Our ref: DOC22/670968-7

Your ref: SSD-9094

Request for advice – Dalswinton Sand and Gravel Quarry – Muswellbrook LGA

BCD's recommendations

Legend

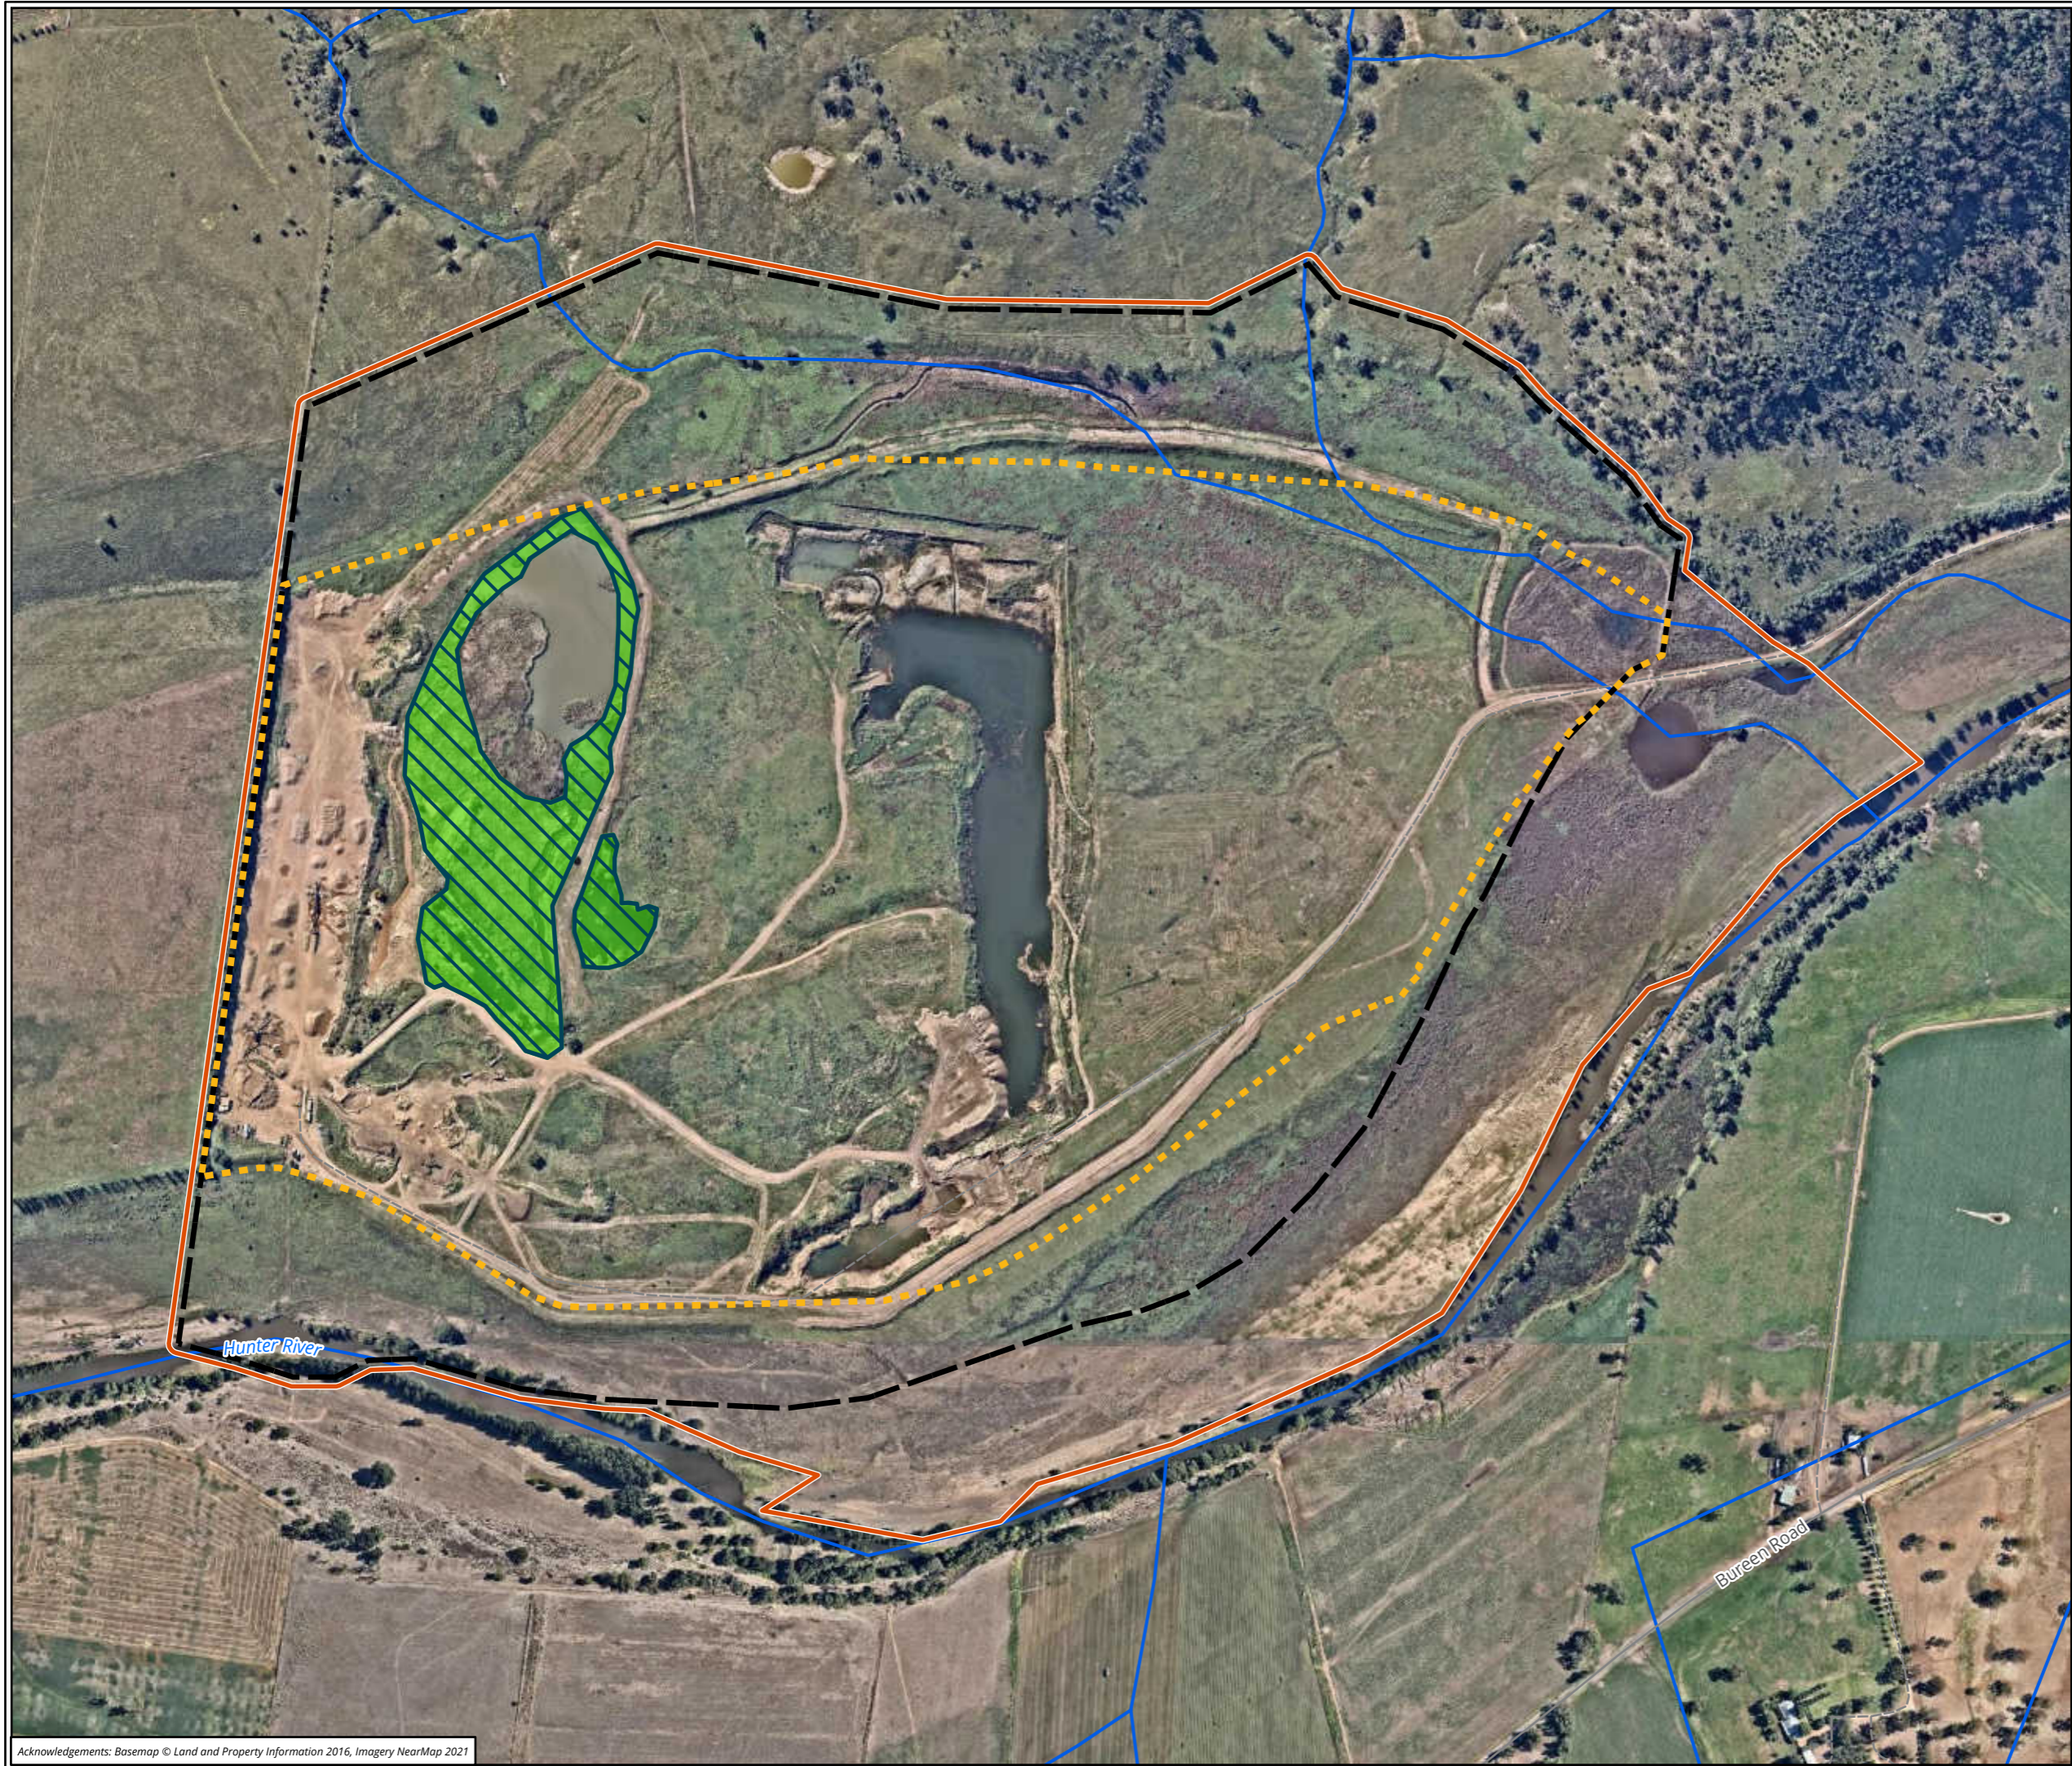
1. An ecologist should be present onsite to supervise the removal of the culvert.

The results of the Biodiversity Development Assessment Report indicate that the southern myotis (*Myotis macropus*) was detected onsite and has the potential to roost in the culvert at the north end of the storage dam. This species is classified as Vulnerable under Schedule 1 of the *Biodiversity Conservation Act 2016*.

Impacts to any individuals potentially roosting in the culvert should be minimised by having a suitably qualified ecologist conduct a pre-clearance survey and being present on to observe the removal of the culvert.

Impacts to any southern myotis (*Myotis macropus*) individuals roosting in the culvert should be minimised through the completion of a pre-clearance survey by a suitably qualified ecologist and if the species is found to be present develop a mitigation plan in consultation with BCD prior to removal of the culvert.
